2023 1096

Variation of conditions 2 and 4 of application 2022/0717 (Change of use from go-karting use to B8 use class (storage and distribution) and the erection of a new detached warehouse building to be used in connection with the existing business (Amended Document and Plans) to allow changes to layout of site and design and scale of new detached warehouse building

Unit 13 and Unit 14, Beevor Street Industrial Estate, Beevor Street, Hoyle Mill, Barnsley, S71 1HN

BLOCK PLAN

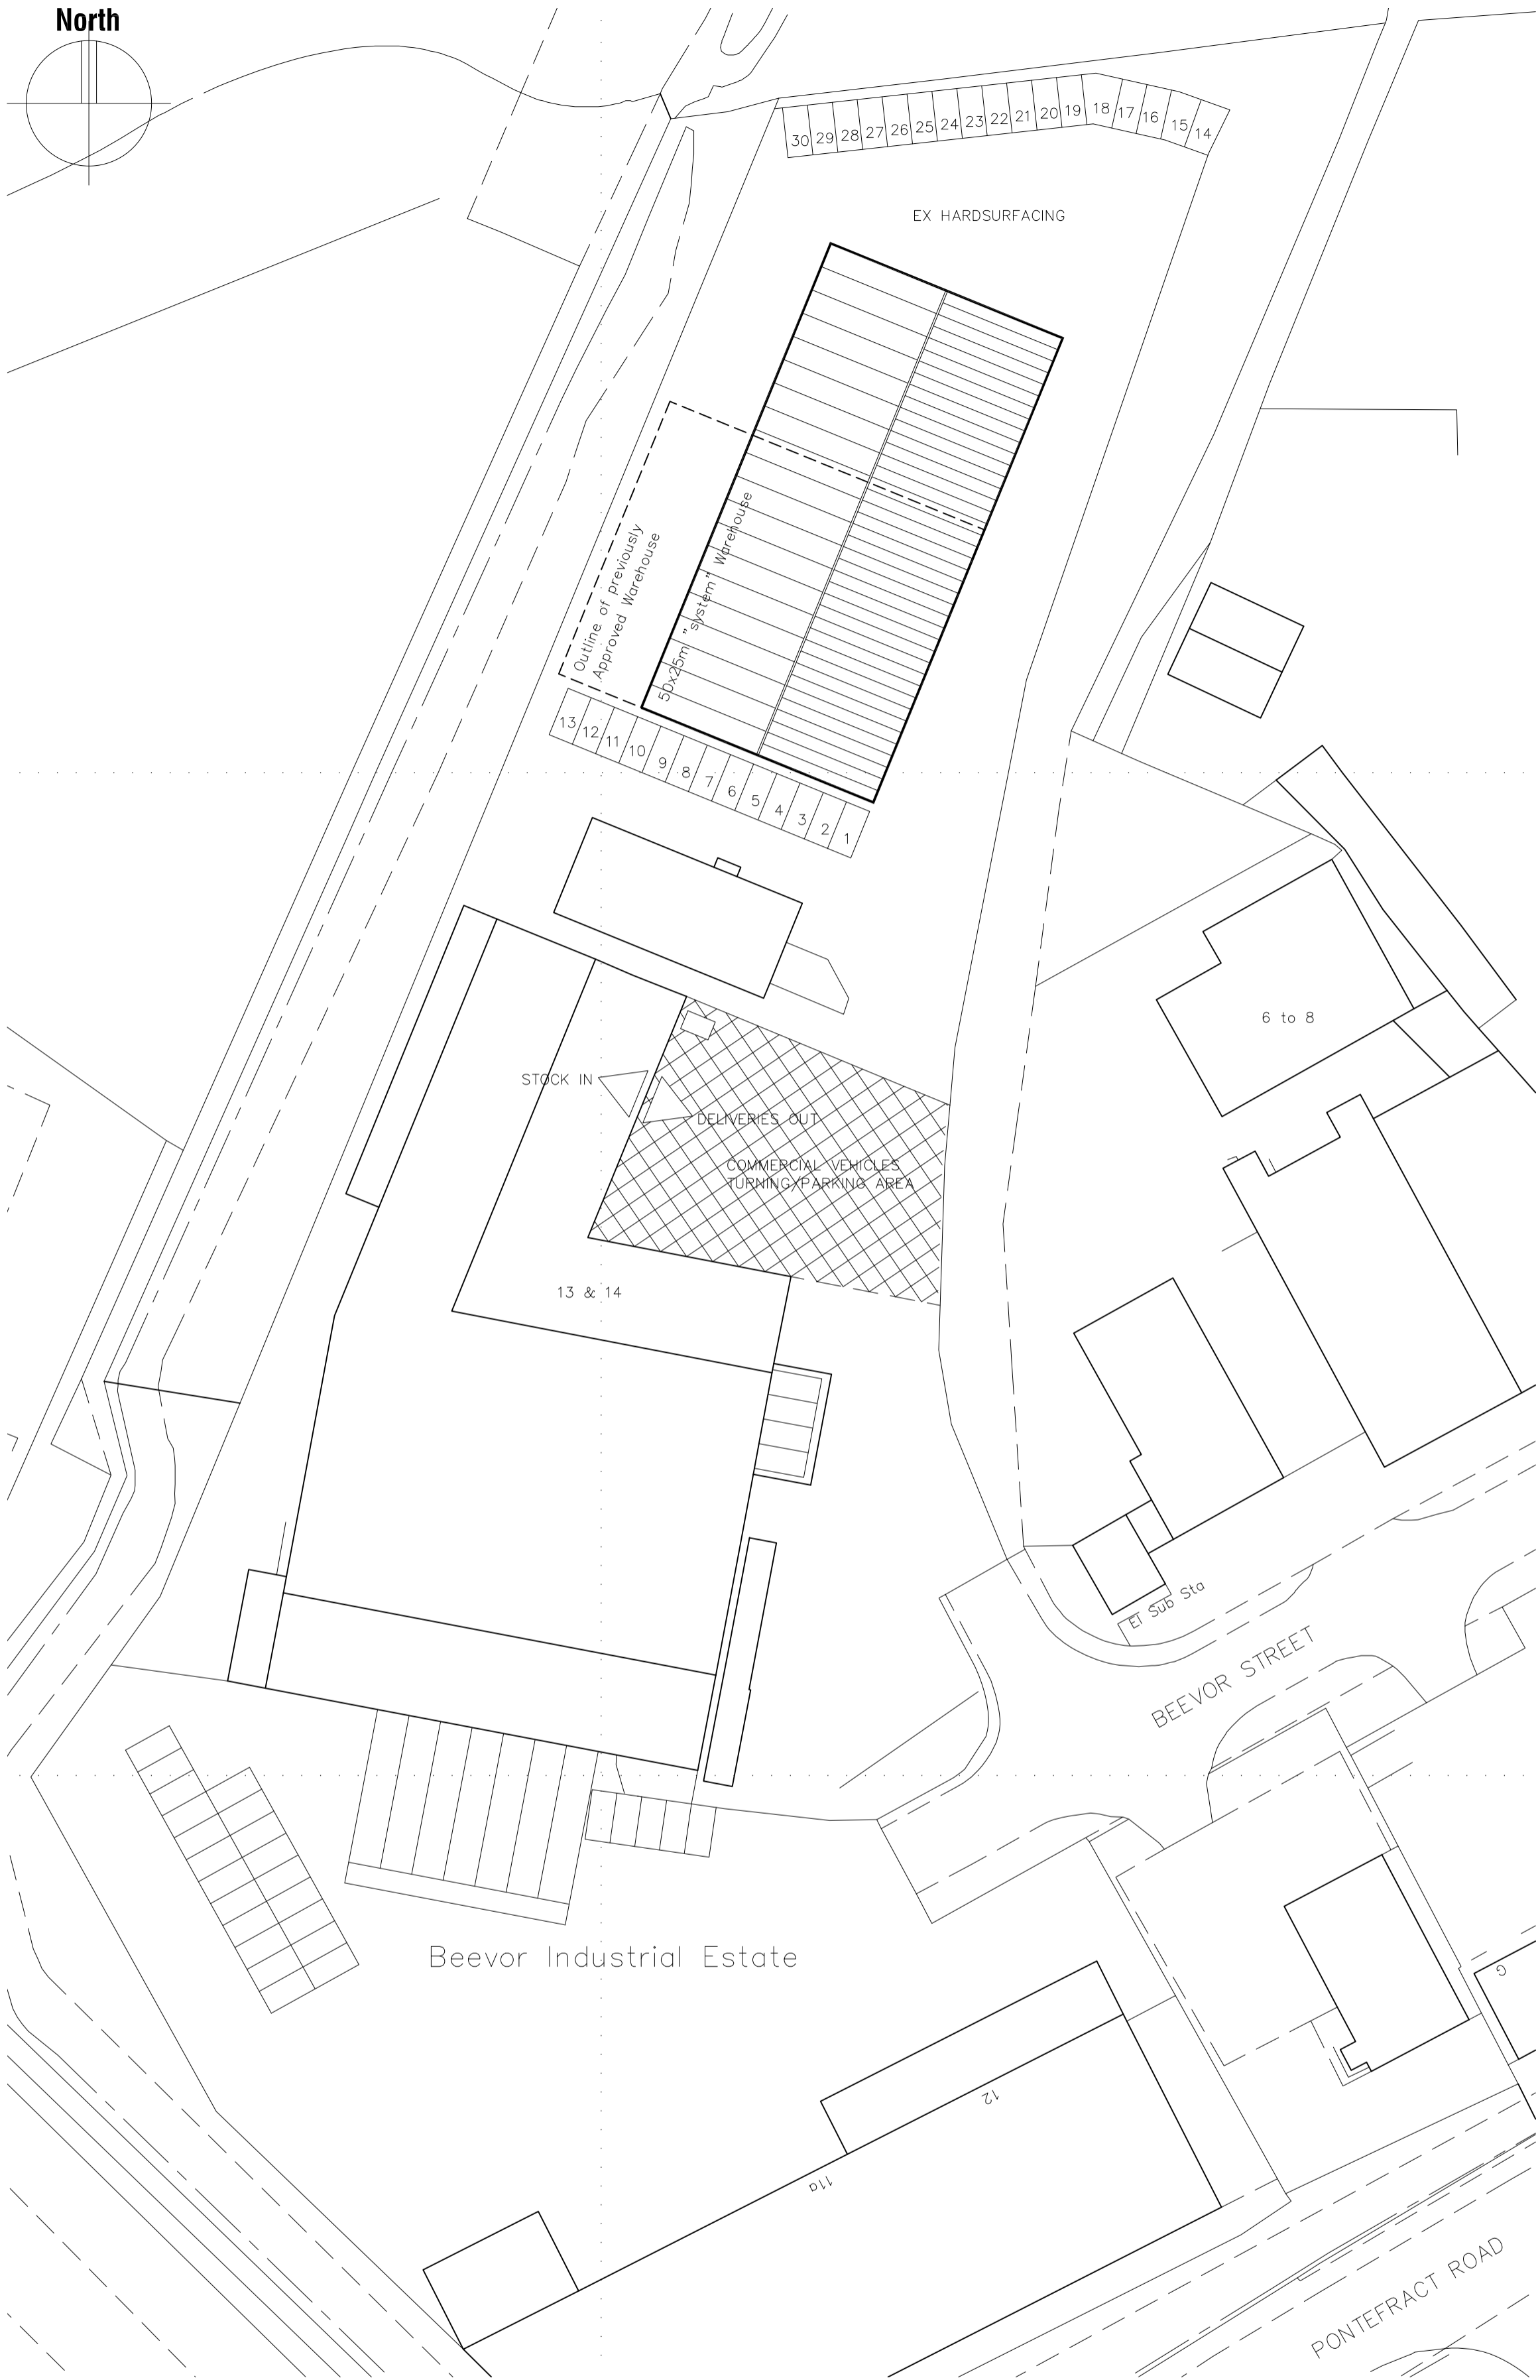
Highways DC – Initial comments expressed concern at the larger warehouse than previously approved and the reduced area available for large vehicles to turn within the site. A designated turning area for Heavy Goods Vehicles should be clearly identified and further information provided in terms of the intended operation of the site including details of the type, size and number of service/delivery vehicles

Reflecting the advice of Highways DC, it is clear that there is sufficient parking and manoeuvring space on the site as demonstrated on the amended block plan. It is concluded that subject to amendment to condition 4 to require the specified parking and turning areas to be delineated and retained for parking/manoeuvring, the proposals are acceptable from a highway safety point of view and in compliance with Local Plan Policy T3.

In response to the amended plan and supporting information, confirmed: It is evident the area designated for parking and turning of delivery vehicles is suitable. The proposed variation of condition 2 is acceptable. Condition 4 is suitable to be amended so that the first part of the condition requiring submission of a scheme showing the delineation of the hard standing area is omitted, however the remainder of the condition is still required in order to ensure the scheme to delineate the parking areas is fully implemented before the new warehouse building is first used.
